ENG-PUDSP21010-R5-PDR.pdf Markup Summary

What are the MDDP flows at DP 34 -- 413 cfs? FEMA flows account for (~1.5 sq mi) at then-existing conditions. Meridian Ranch MDDP - DP-G06 1.45 sq. mi., historic Q100=628, developed 663 cfs should be referenced also. See MDDP in SKP-17-1 file.

**PROPOSED DRAINAGE MAP**

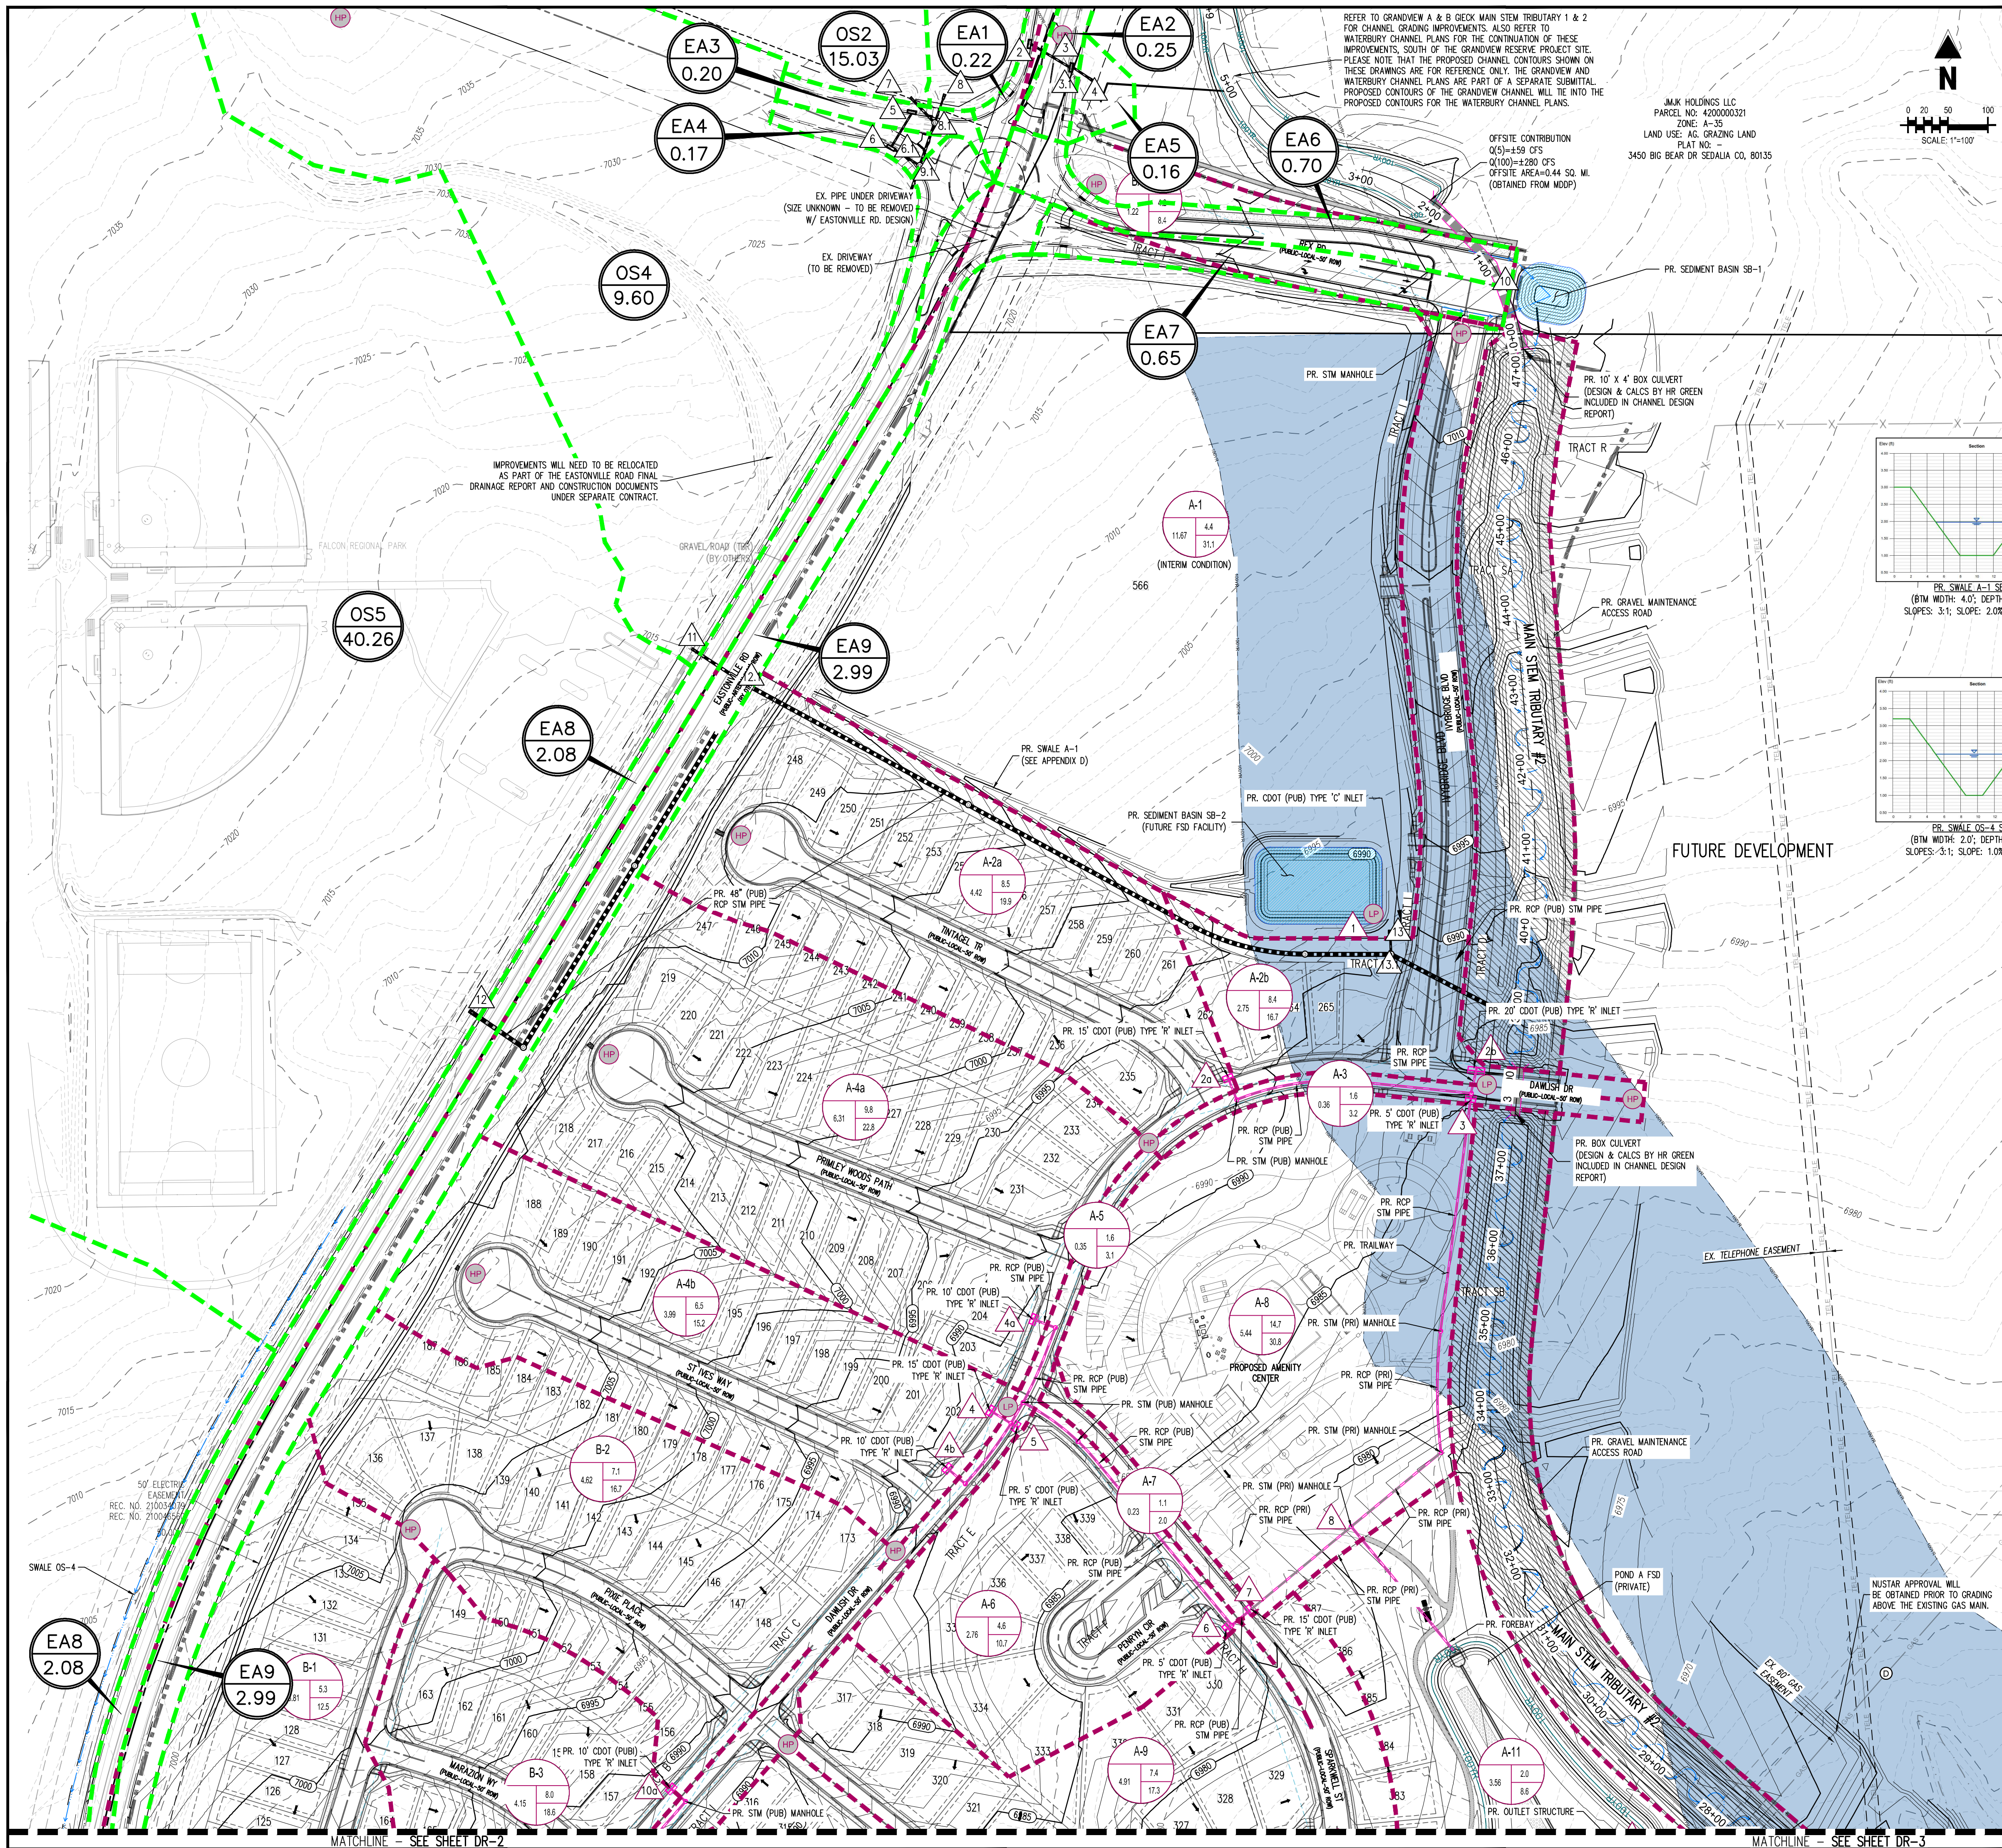
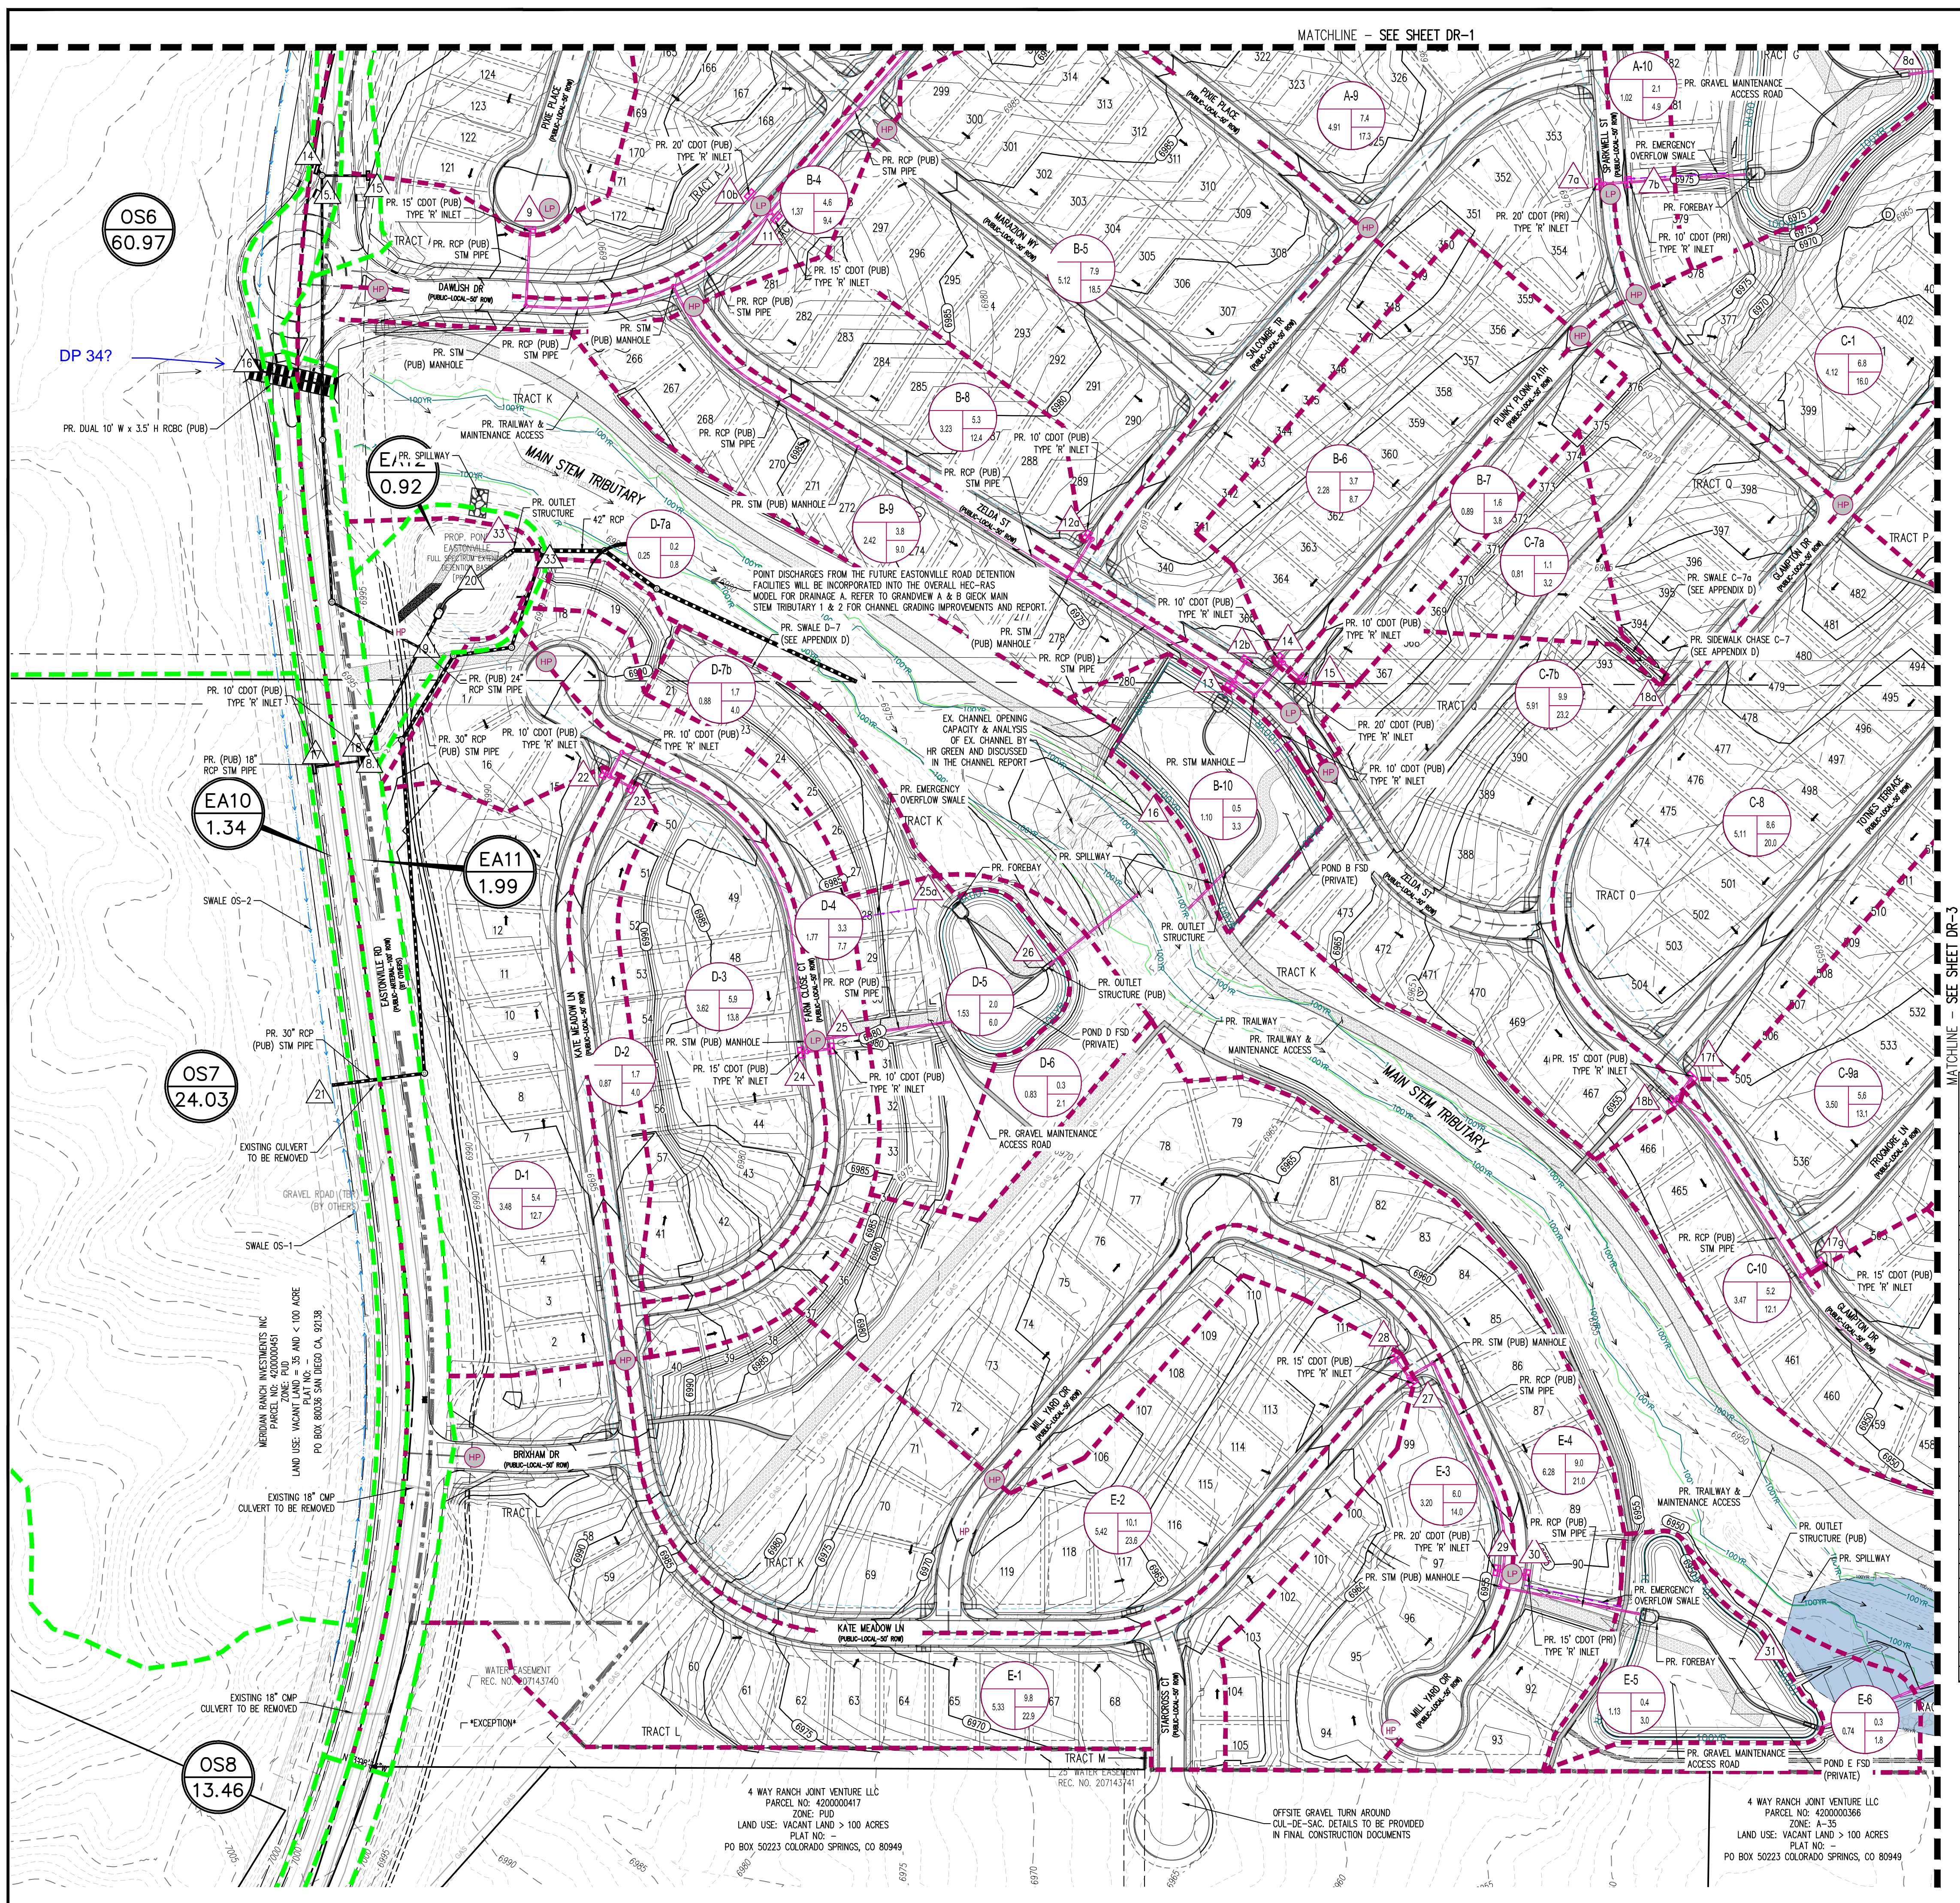
Address the remaining design points with culverts or pipes DP32-DP35. Add lines or text.

Label DP35(?)

Show location on a plan sheet

Refer to Eastonville Road FDR

REVISED
